15 December 2016
Our Ref: N26522
Your Ref: DA 485-12-2002 MOD 1

**REQUEST TO MODIFY A DEVELOPMENT APPROVAL UNDER SECTION 75W OF THE EP&A ACT _
DEVELOPMENT APPLICATION 485-12-2002 MOD 1 - MODIFICATION TO RESIDENTIAL SUBDIVISION AT
NADINE STREET, SANCTUARY POINT**

Comments on Agency & Public Submissions

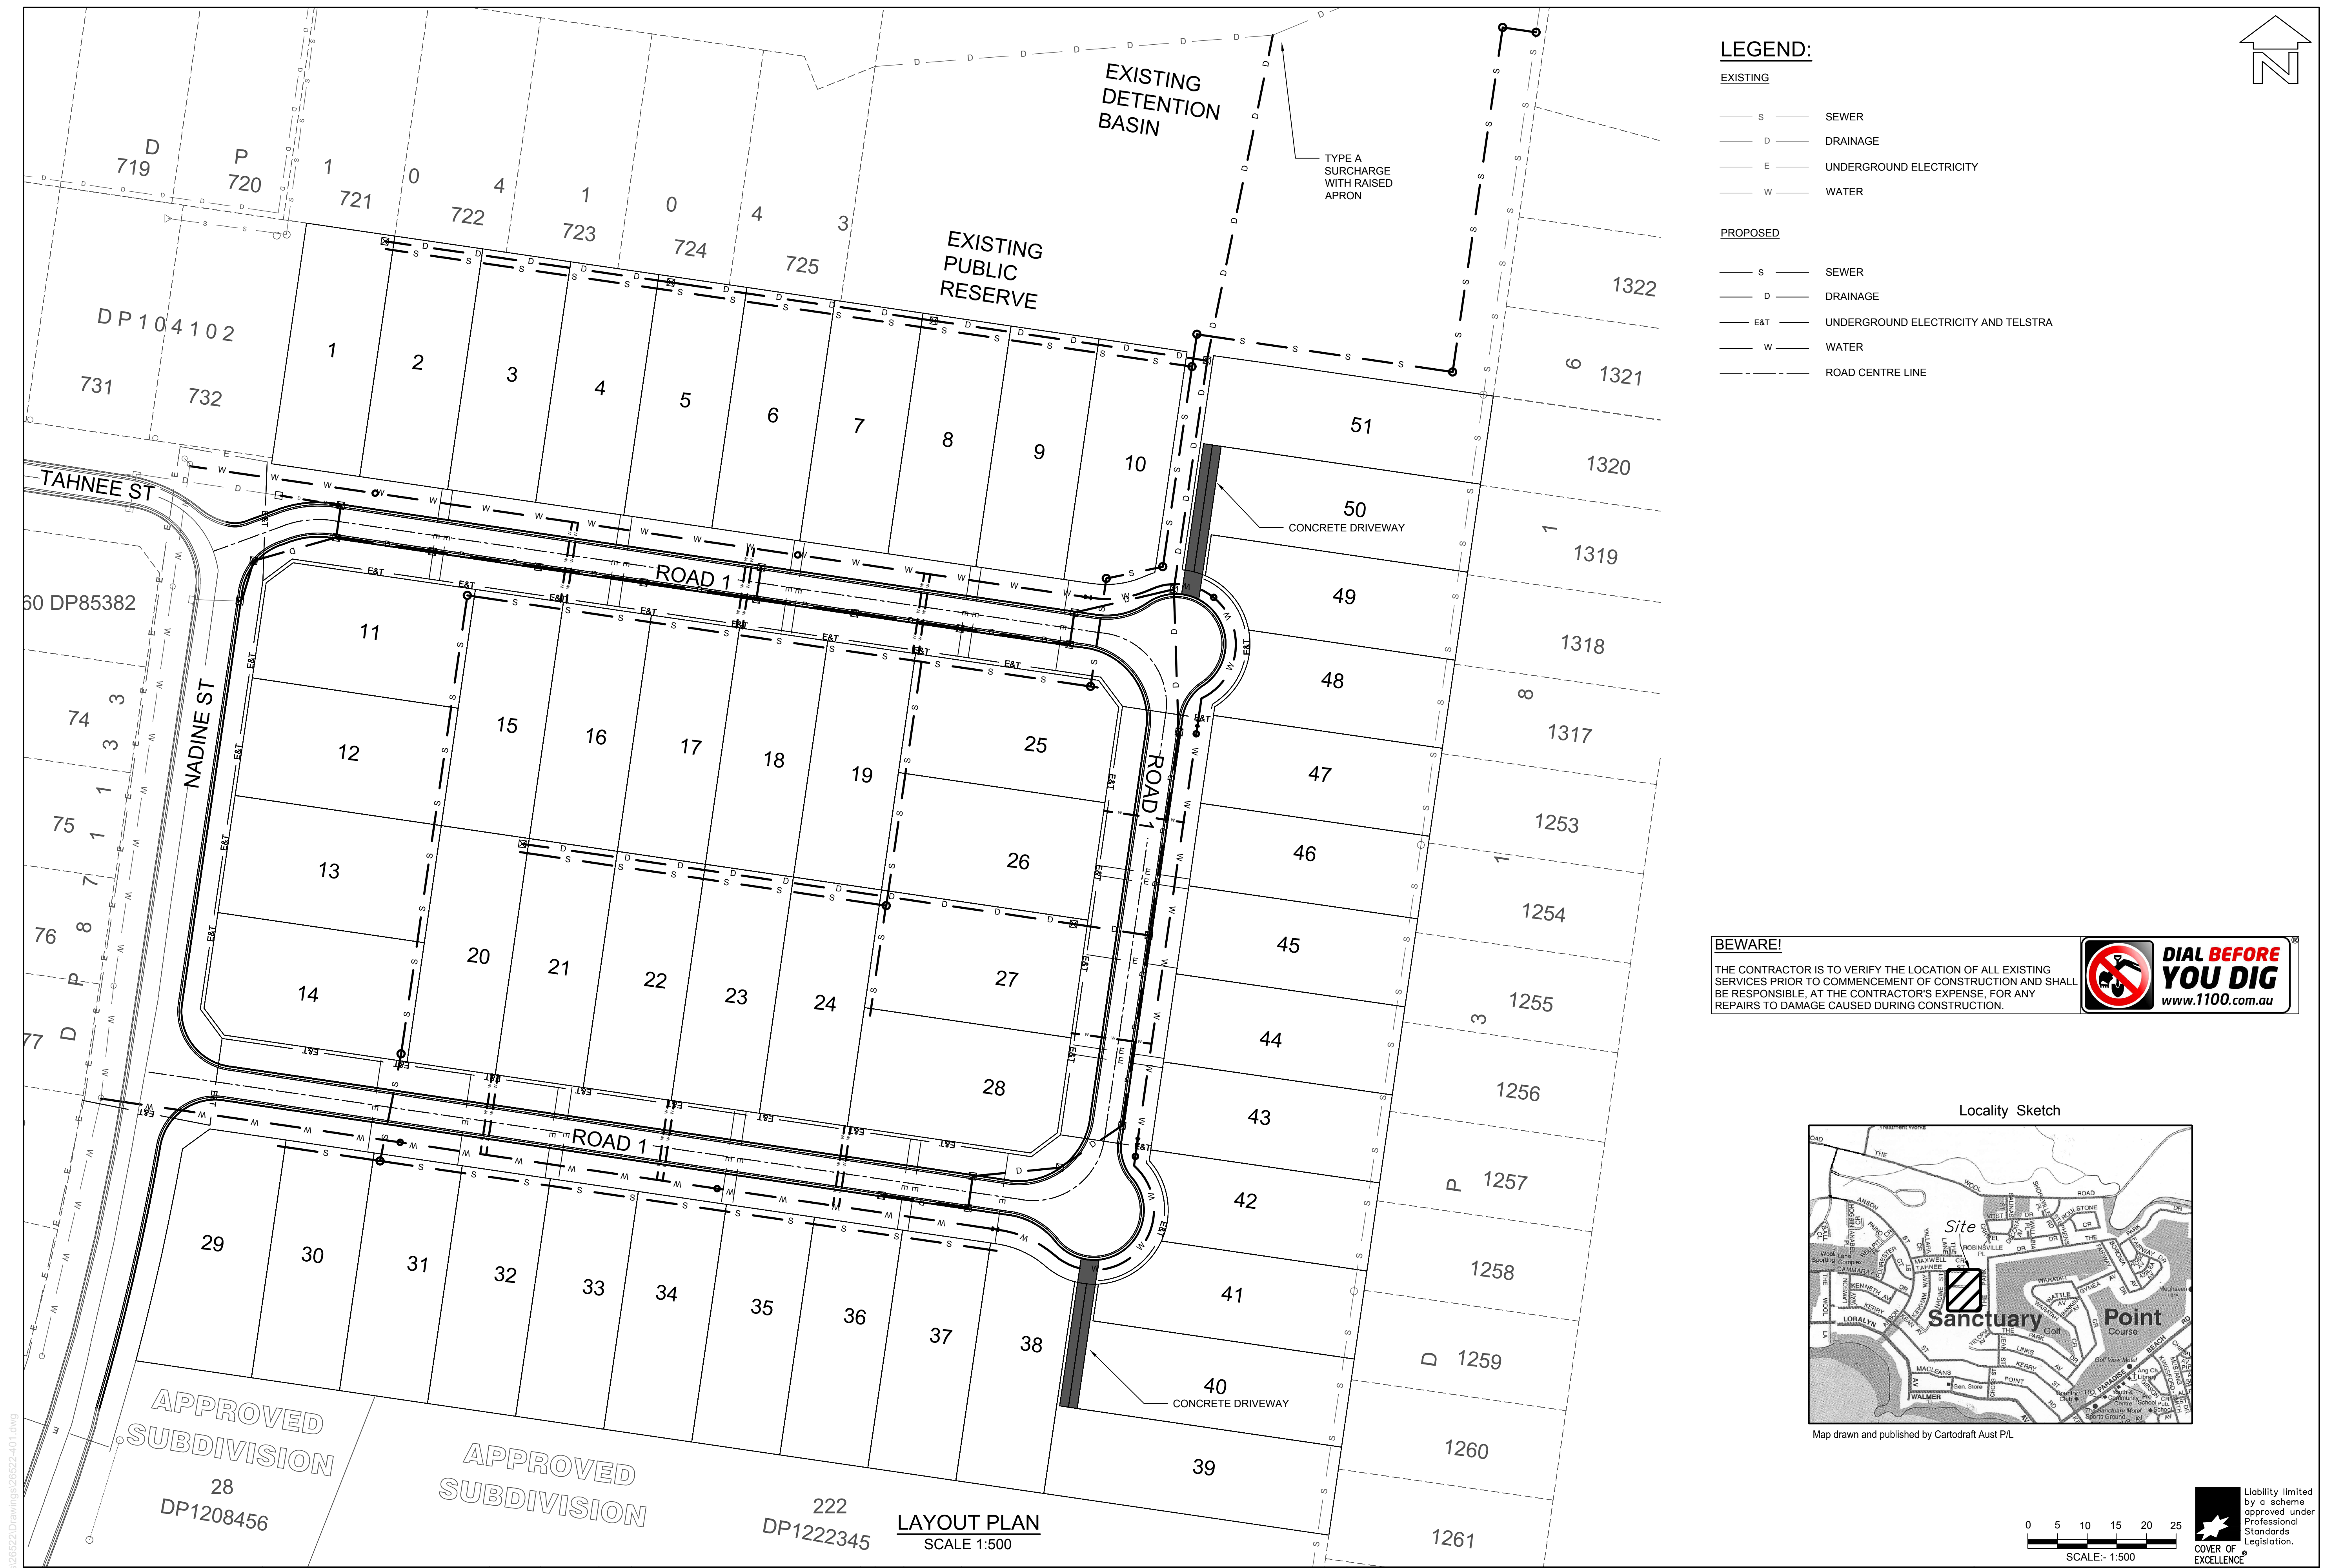
Shoalhaven City Council	<ul style="list-style-type: none"> • Council is concerned at the removal of the detention basin, given the sensitivity of the nearby St Georges Basin. Prior to any further consideration of the modification application the applicant must provide 	<ul style="list-style-type: none"> • A revised concept engineering plan accompanies this S75W application that includes inter-allotment drainage details. Separate documentation also accompanies this application for on-site detention calculations. The proposed concept engineering ensures the protection of downstream water bodies by way of minimising the impact of stormwater runoff generated by the development.

Agency	Detail of Issue	Response to Submission
	<p>preliminary stormwater plan that includes on-site detention calculations, inter-allotment drainage details and owner's consent for works on adjoining land. This alternative strategy must ensure protection of downstream water bodies.</p> <ul style="list-style-type: none"> • There is insufficient information regarding verge widths, location of services and landscaping; and radii of the knuckles to support the reduction in the road widths. • The increased lot density and reduced lot widths: <ul style="list-style-type: none"> 1. Have not been considered with respect to the potential for overshadowing; 	<p>Council is the owner of the adjoining land (Lot 715 DP1019410), to which the stormwater drainage is proposed. It is respectfully requested that a condition of consent be imposed, requiring owner's consent to be provided prior to the issue of a construction certificate for works in the adjoining land.</p> <p>Allen Price and Scarratts has made an application to Council seeking consent for drainage and sewer works to be completed on adjoining lot (Lot 715 DP1019410).</p> <ul style="list-style-type: none"> • Revised concept engineering plans detail information relating to verge widths, location of services and landscaping and radii of the knuckles. You should note that the road carriageway width remains at 5m, as conditioned in the original development consent. It is proposed to reduce the road verge widths to meet the current requirements of the Shoalhaven Development Control Plan (DCP) 2014. • The residential allotments are proposed to be 15m or greater in width. Residential home builders have numerous single storey designs that can accommodate for a 15m allotment width. Appropriately designed dwellings can alleviate the potential for overshadowing, which can be assessed on its merit at dwelling application stage, or in accordance with State Environmental Planning Policy (SEPP) (Exempt and Complying Development Codes 2008).

Agency	Detail of Issue	Response to Submission
	<p>Proposed drainage to adjoining Lot 715 DP 1019410 requires works to be carried within Council lands, as such, land owner's consent is required for this application.</p> <p>Inter-allotment drainage is required to drainage Lots 1 – 10, 50 and possibly Lot 49. No information has been provided as to how these lots will be connected to the proposed drainage reserve.</p> <ul style="list-style-type: none"> • Inter-allotment Drainage - As mentioned above in (f) roof area and hard stand areas should be restricted to reduce stormwater issues. Inter-allotment Drainage should be considered for the above properties. <p>Any inter-allotment drainage should also have an 88b restriction outlining who is responsible for maintenance of the drainage line.</p> <p>All junctions should be drawn on the</p>	<p>approved plans with OSD in the form of oversized stormwater tanks on each lot.</p> <ul style="list-style-type: none"> • As previously stated, Council is the owner of the adjoining land (Lot 715 DP1019410), to which the stormwater drainage is proposed. It is respectfully requested that a condition of consent be imposed, requiring owner's consent to be provided prior to the issue of a Construction Certificate for works in the subject land. <p>Allen Price and Scarratts has made an application to Council seeking consent for drainage and sewer works to be completed on adjoining lot (Lot 715 DP1019410).</p> <ul style="list-style-type: none"> • The most recent proposed alteration to the lot layouts has resolved the Inter-allotment drainage issues. Please see the revised concept engineering plan. • Proposed inter-allotment drainage is designed in accordance with the requirements of the DCP. Roof and hard-stand areas shall be determined by Council in accordance with the applicable planning legislation upon future Development Applications for dwellings. • It is acknowledged that inter-allotment drainage shall have an 88b restriction outlining who is responsible for maintenance of the drainage line. • The location of junctions shall be readily available and detailed on

A revised plan, titled Drawing number 26522-402; Sheet 1-2 of 2; Revision 1; details of On-Site-Detention and a plan detailing trees marked for retention accompanies this letter.
